# CITY OF ALBUQUERQUE

October 3, 2022

**Re: Fliz Drinks**  
**Corner of Cottonwood Dr. and Old Airport Rd. NW**  
**Traffic Circulation Layout**  
Architect's Stamp xx-xx-xx (A14-D049)

Based upon the information provided in your submittal received 09-14-22, the above referenced plan cannot be approved for Building Permit until the following comments are addressed:

FIIZ DRINKS ALBUQUERQUE, NM	DRAWN BY JL
	TRAFFIC CONTROL LAYOUT	DATE 7-14-22
	5571 MIDWAY PARK PL NE ALBUQUERQUE, NEW MEXICO 87109 (505) 858-3100 www.tierrawestllc.com	DRAWING
RONALD R. BOHANNAN P.E. #7868	10/19/2022	SHEET # TCL-1
		JOB # 2022048

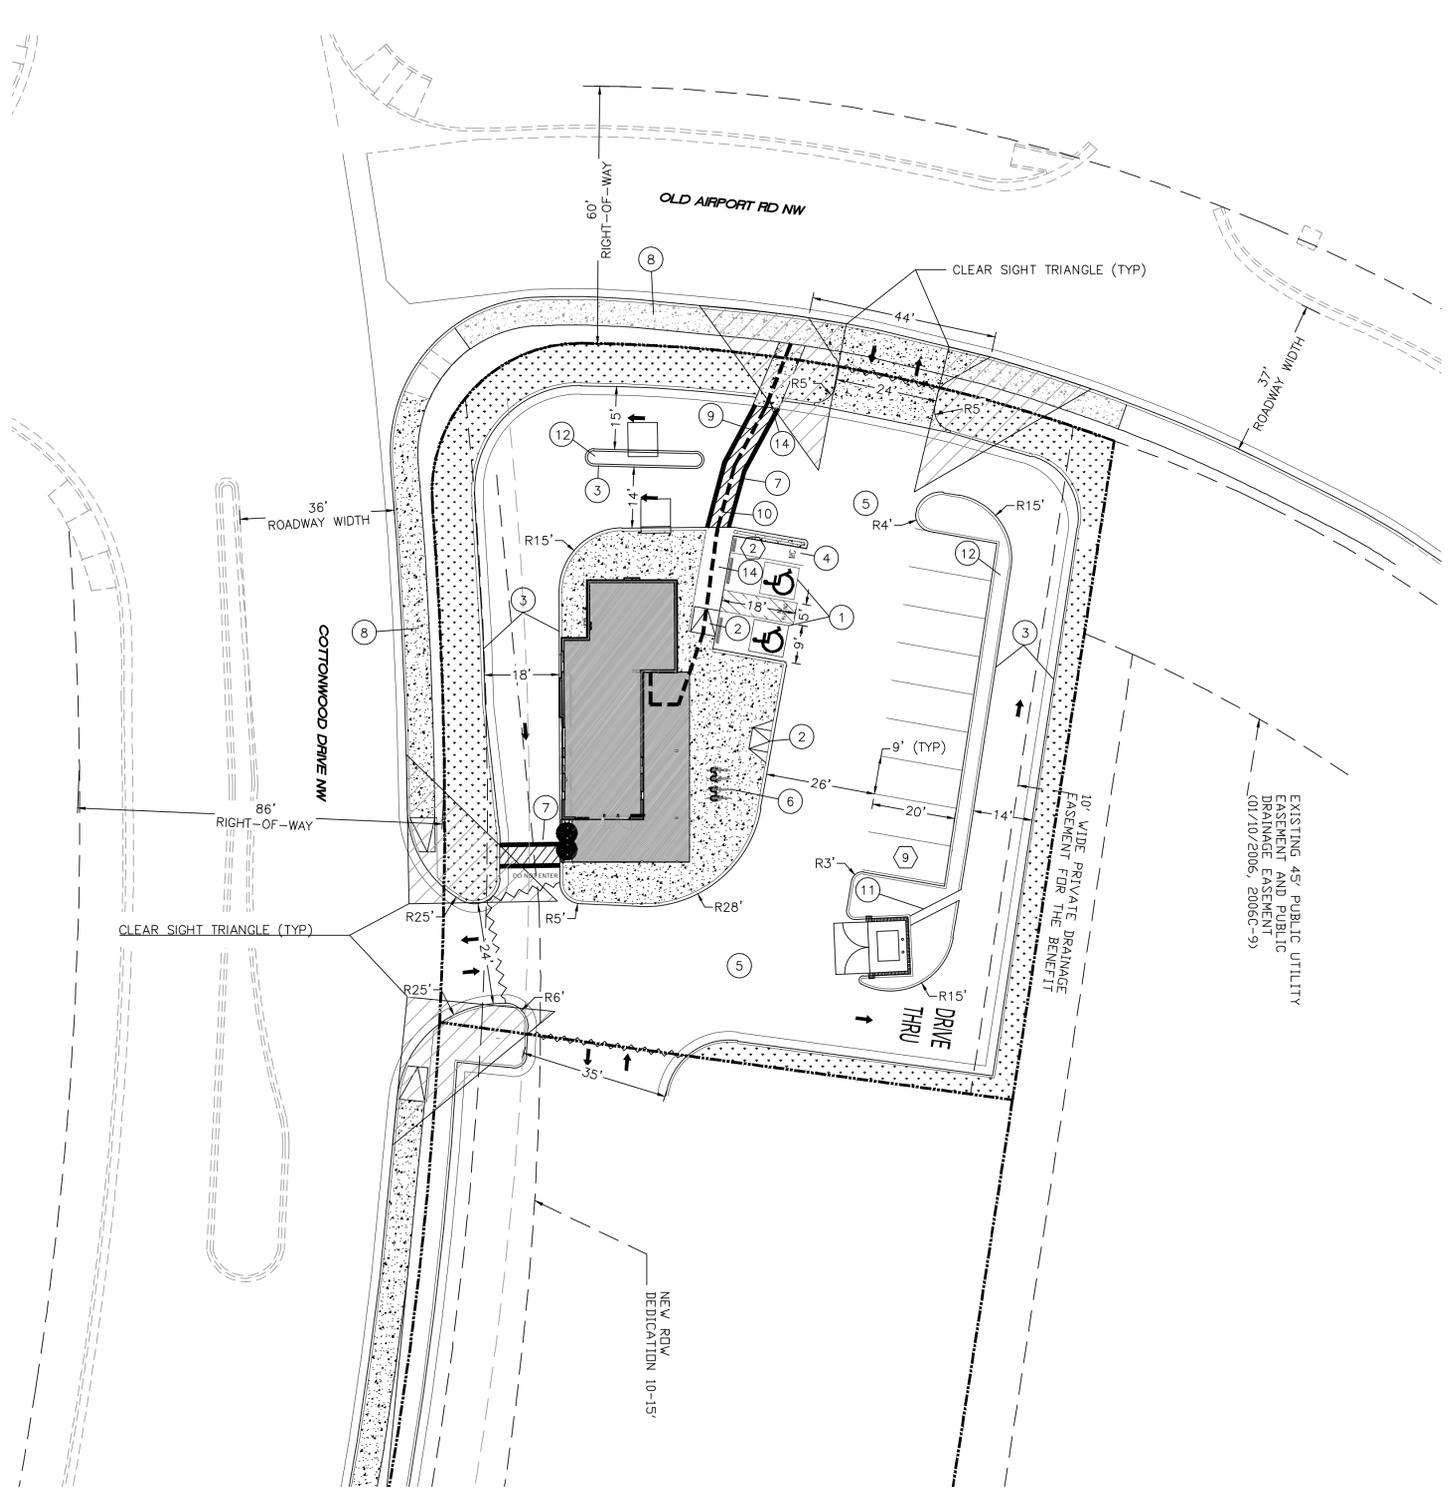
1. The traffic circulation layout must be stamped, signed, and dated by an engineer or architect licensed in the state of New Mexico.
2. Identify the right of way width, medians, curb cuts, and street widths on Old Airport Rd. and Cottonwood Dr.

3. Please provide Curb Return Design for both driveways' accesses of Old Airport and Cottonwood Dr. and reference COA std dwg 2426.
4. The ADA accessible spaces must include an access aisle. Van accessible aisles should be 8ft wide; all others should be 5ft wide.

5. Provide details for the interior ADA ramp.
6. The ADA accessible parking sign must have the required language per 66-7-352.4C NMSA 1978 **"Violators Are Subject to a Fine and/or Towing."** Please call out detail and location of signs.

7. ADA curb ramps at the corner of Old Airport Rd. and Cottonwood Dr. must be updated to current standards and have truncated domes installed. Please clarify if the existing ramp is ADA compliance.

13. List radii for all curves shown; for passenger vehicles. Radius for delivery trucks, fire trucks, etc. is 25 ft. or larger.
14. Key note 7: Per the IDO, a 6 ft. wide ADA accessible pedestrian pathway is required from the public sidewalk to the building entrances. Please clearly show this pathway and provide details.

15. Per DPM, a 6 ft. wide ADA accessible pedestrian pathway is required from the ADA parking stall access aisles to the building entrances. Please clearly show this pathway and provide details.

16. ADA accessible pedestrian pathway should not be placed behind parking space or adjacent to a vehicular way. Vehicle and pedestrian/wheel chair conflicts should be avoided as much as possible.

17. Define ADA pathways by labeling of ramps, flush pavement, dimensioning of pathways, doorways, etc.
18. Refuse vehicle maneuvering shall be contained on-site. The refuse vehicle shall not back into the public right of way.; provide a copy of refuse approval.

22. Please add a note on the plan stating "All improvements located in the Right of Way must be included on the work order."
23. Add a note stating "All broken or cracked sidewalk must be replaced with sidewalk and curb & gutter." A build note must be provided referring to the appropriate City Standard drawing.

TYPICAL HANDICAP AND MOTORCYCLE PARKING
NTS

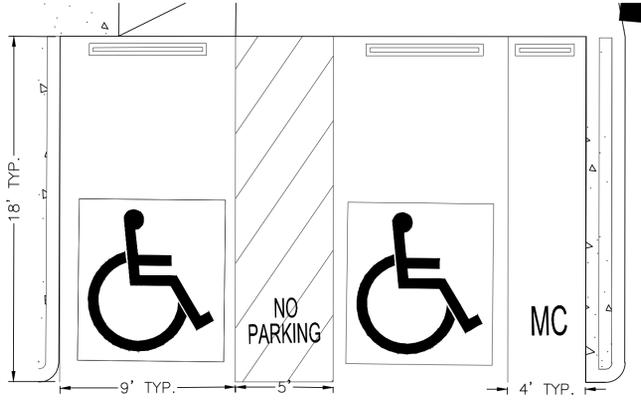
8. Provide Motorcycle parking space's details.
9. All bicycle racks shall be designed according to the following guidelines:
  - a. The rack shall be a minimum 30 inches tall and 18 inches wide.

BIKE RACK DETAIL
SCALE: NTS

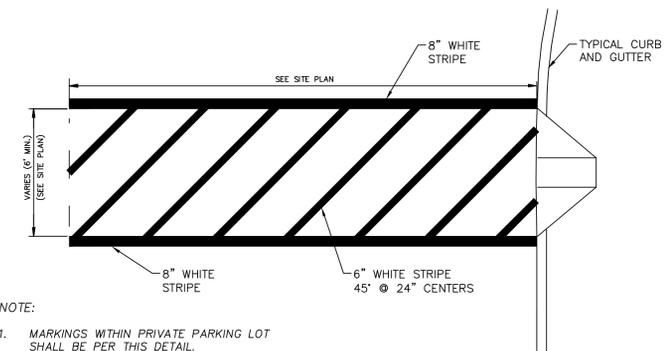
- b. The bicycle frame shall be supported horizontally at two or more places. Comb/toaster racks are not allowed.
  - c. The rack shall be designed to support the bicycle in an upright position. See the IDO for additional information.

- d. The rack allows varying bicycle frame sizes and styles to be attached.
  - e. The user is not required to lift the bicycle onto the bicycle rack.

- f. Each bicycle parking space is accessible without moving another bicycle.

10. Bicycle racks shall be sturdy and anchored to a concrete pad.
11. A 1-foot clear zone around the bicycle parking stall shall be provided.
12. Bicycle parking spaces shall be at least 6 feet long and 2 feet wide.
